Date: 05/08/2025

Re: **Framing Issue**
Location: Lot 8 Campbell Ridge (214 Alden Way Angier, NC)
JDS Project No.: RDU2504867
Date of Inspection: 05/08/25

1 CRAWLSPACE FOUNDATION PLAN
SCALE: 1/8"=1'-0"

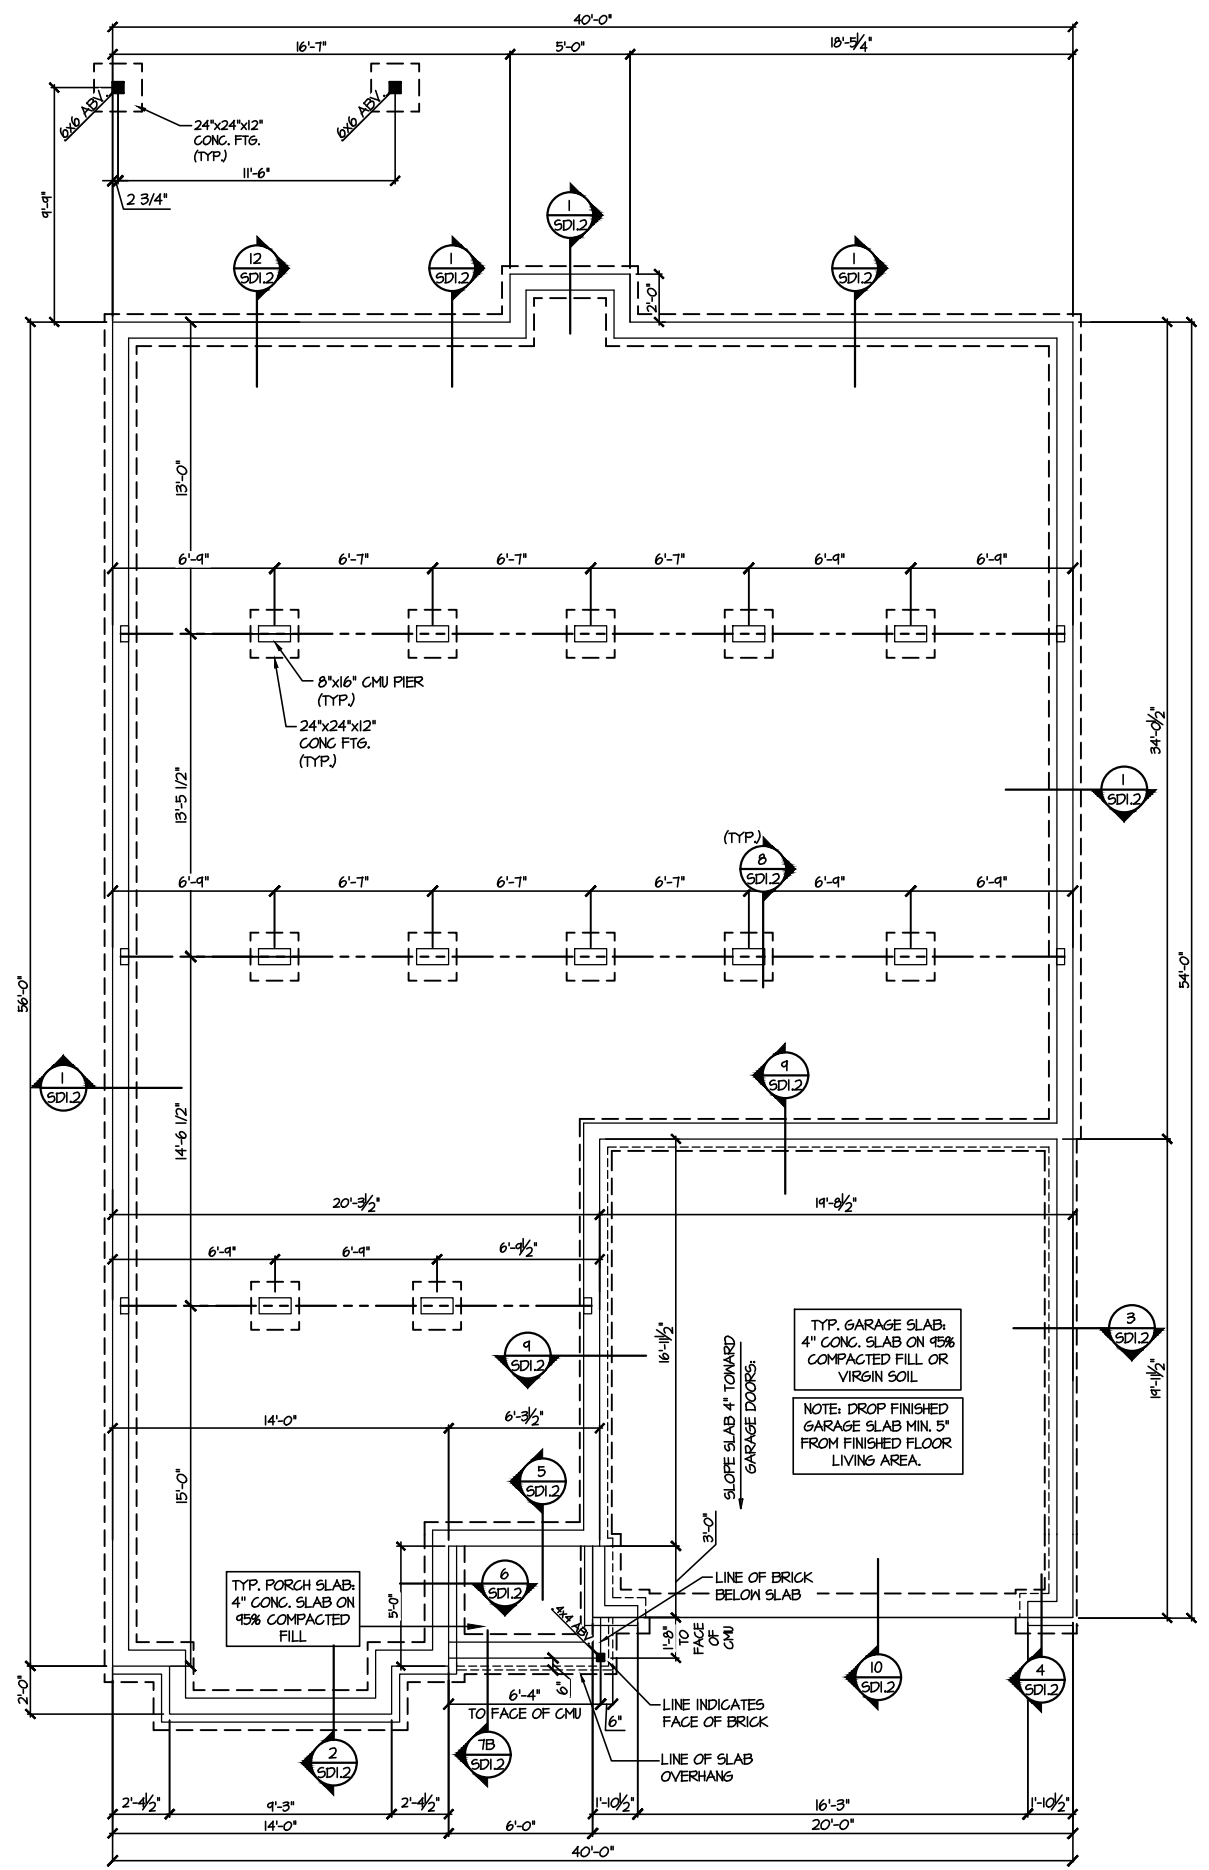
1. The inspector is questioning the (2) ply LVL above the living room entryway that was notched at both ends at the top corners of the LVL to fit the adjacent wall's top plates.
2. All (3) of the (3) ply 2x12 drop beams in the crawlspace have been notched to allow the small pony wall to sit flush along the CMU blocking around the house. The framers have notched approximately an approximately 6" long by 3" deep "L" notch in each end of each drop beam.

1. The (2) ply LVL is acceptable as installed with the end notches for the top plated. No further action is required.
2. The (3) ply 2x12 drop beams in the crawl spaced are acceptable as installed with the end notches for the pony walls. No further action is required.
